**KIRKLEES COUNCIL
TOWN AND COUNTRY PLANNING ACT 1990
HIGHWAYS DEVELOPMENT MANAGEMENT**

PLANNING REF 2017/62/90620/W0/MW
CATEGORY Small Major

PROPOSAL DEMOLITION OF EXISTING BUILDINGS, CHANGE OF USE OF EXISTING BUILDING TO MIXED USES COMPRISING B1A, B1C, A3, C3 AND OUTLINE PERMISSION FOR ERECTION OF 75 DWELLINGS

LOCATION DOBROYD MILLS
HEPWORTH ROAD
NEW MILL
HOLMFIRTH
HD9 1AF

DRAWING No: 1604601c

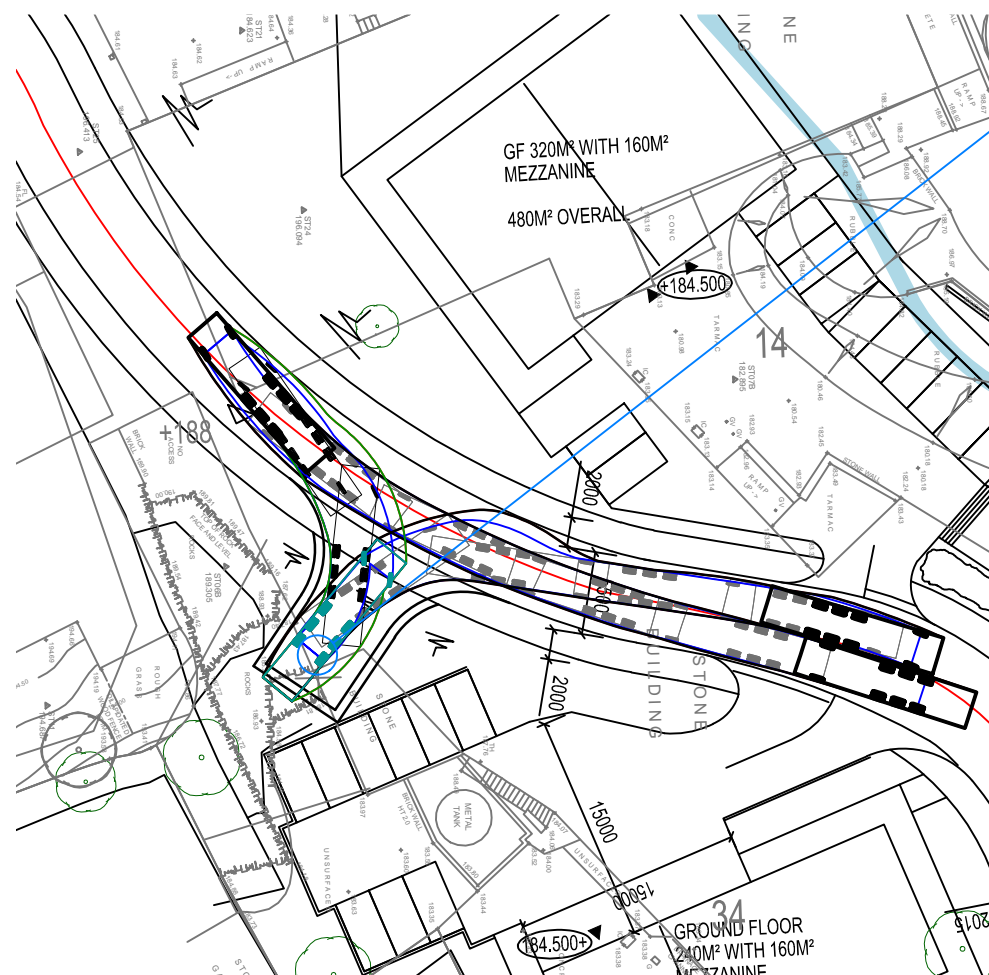
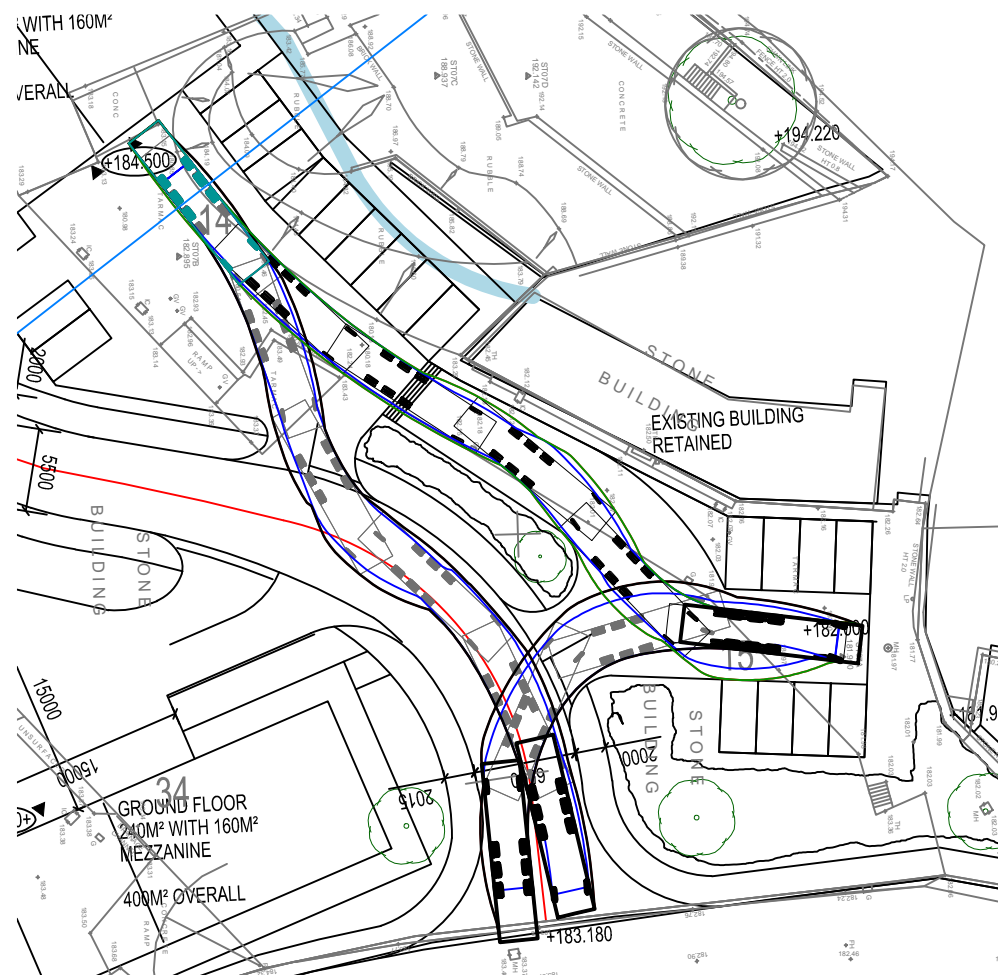
The swept paths for an 11.85 metre refuse vehicle provided demonstrate that a refuse vehicle will find turning and manoeuvre within the site difficult involving the need to reverse the full length of the proposed car park to the western side of the development. A refuse vehicle cannot access and turn within the eastern side of the development.

No bin storage and collection points are shown on the plans and given that a refuse vehicle will find access and turning within the proposed car parks difficult Highways would consider that these should be sited in a location that will allow collection from the main spine road.

Details of bin collection and storage points and motor cycle parking and cycle storage needs to be provided.
